Subject: PLANNING APPLICATION NO: AB/3/21/PD

Drawing Title:
PROPOSED ELEVATIONS

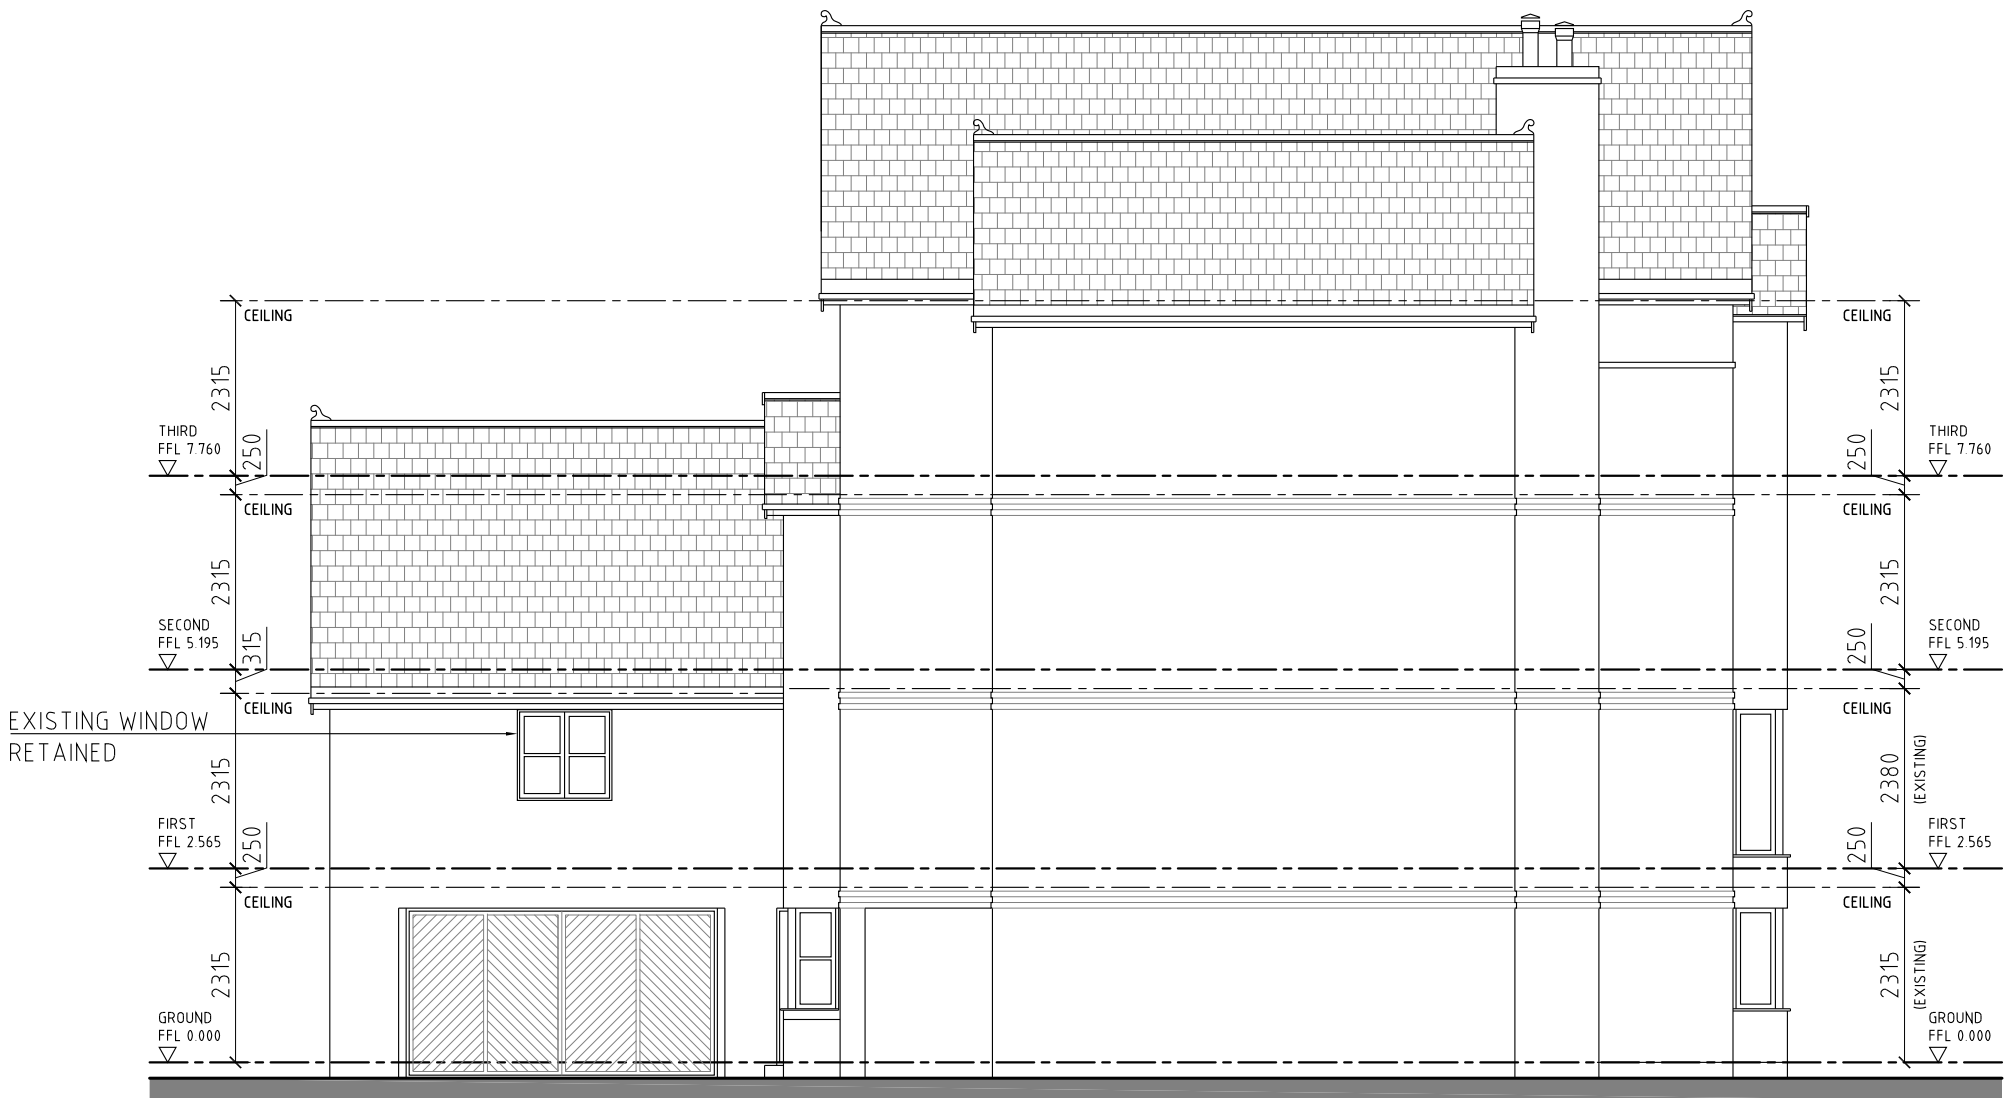
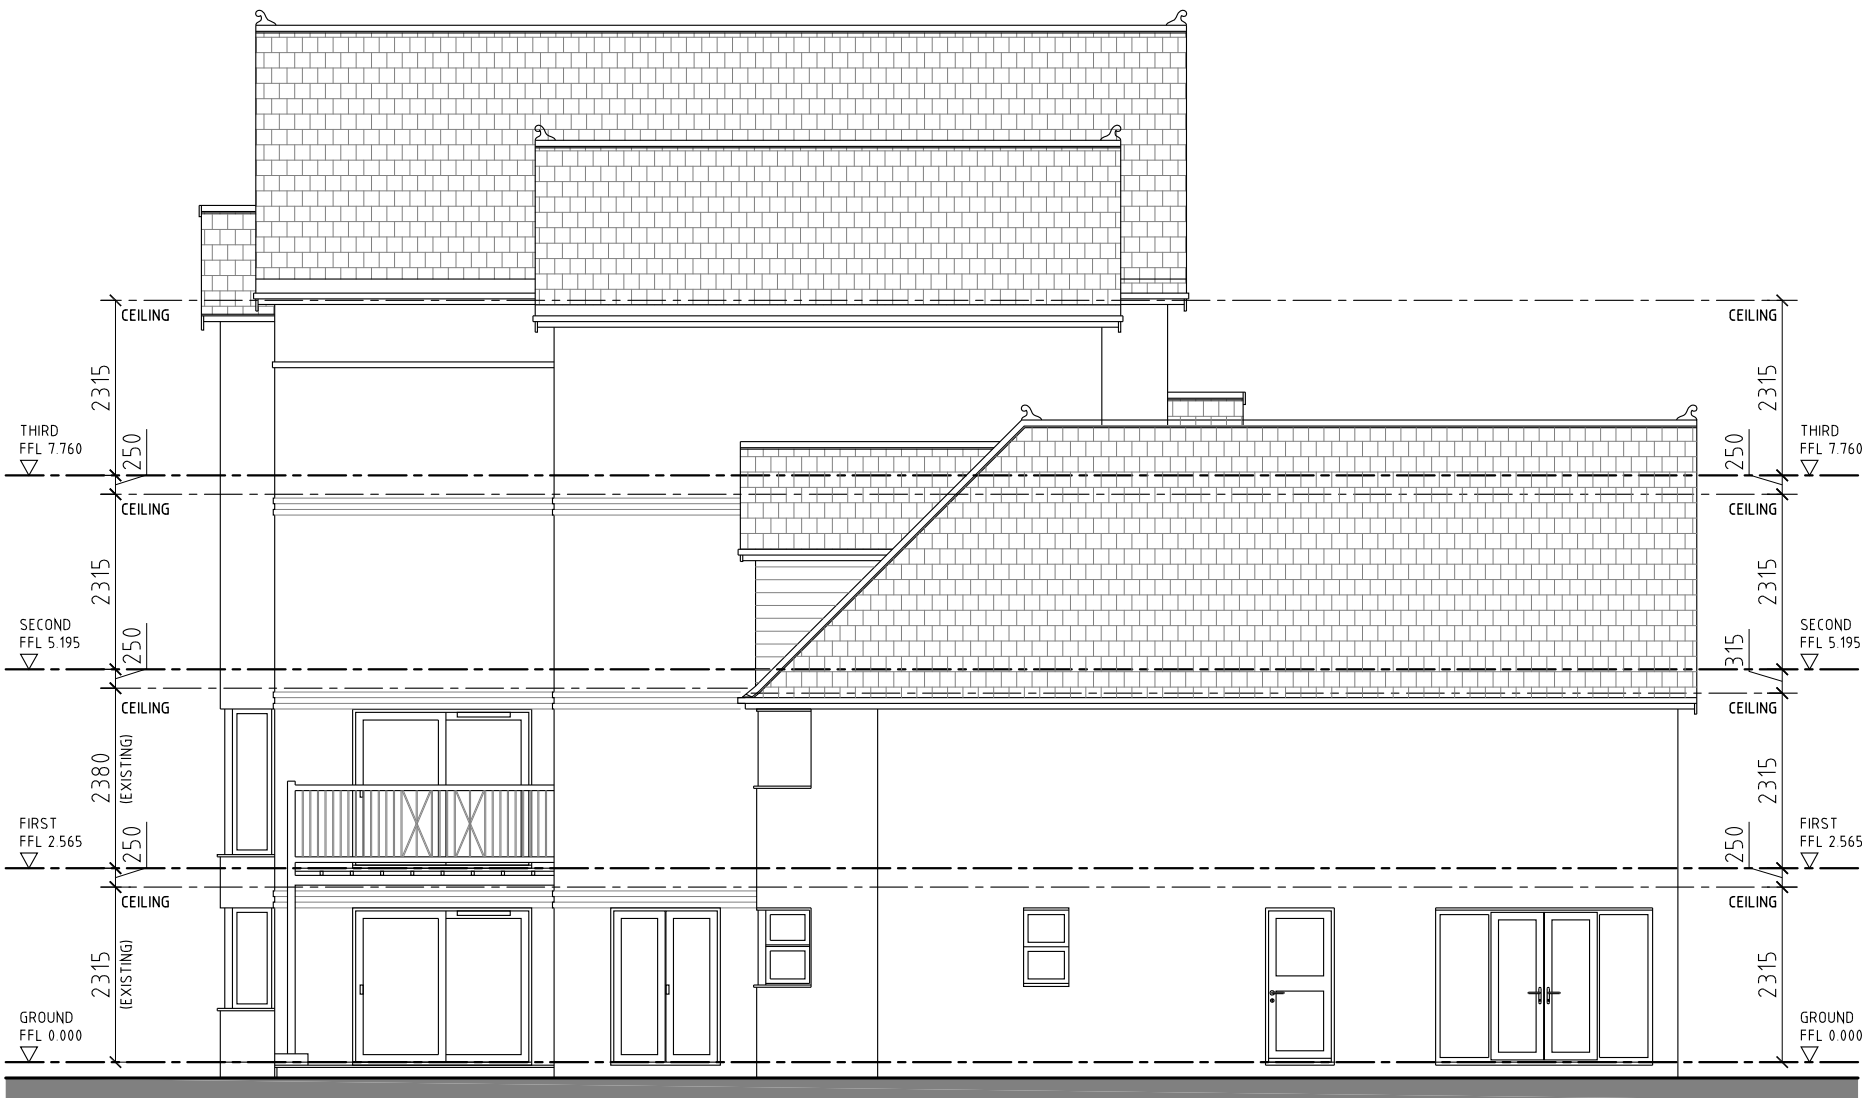
The property is set in an open and mostly suburban streetscape of small residential properties of one or two storeys. Although it is bordered on one side by Martlets Court, there are no other single residential properties that extend to four storeys anywhere in the vicinity. The proposed extension would make this property uncharacteristically tall, and a bulky inset that is out of keeping with the street scene. It therefore contravenes Arun Local Plan 2011-2031 which states that: "all extensions and alterations which are visible on the street-scene, should respect the established spatial character and pattern of the street, and make a positive contribution to the locality."

The height and bulk of this proposed extension, which will be directly next to normal houses of two storeys, will cause these properties loss of sunlight and privacy. Also, whereas in the current situation there are mature and semi mature trees to provide some screening and privacy, the extension will be of such height that it will rise above the tree heights and be intrusive/dominate the immediate locality. The bulk and height of the proposed extension would also negatively impact the conservation area on the North side of the River Arun.
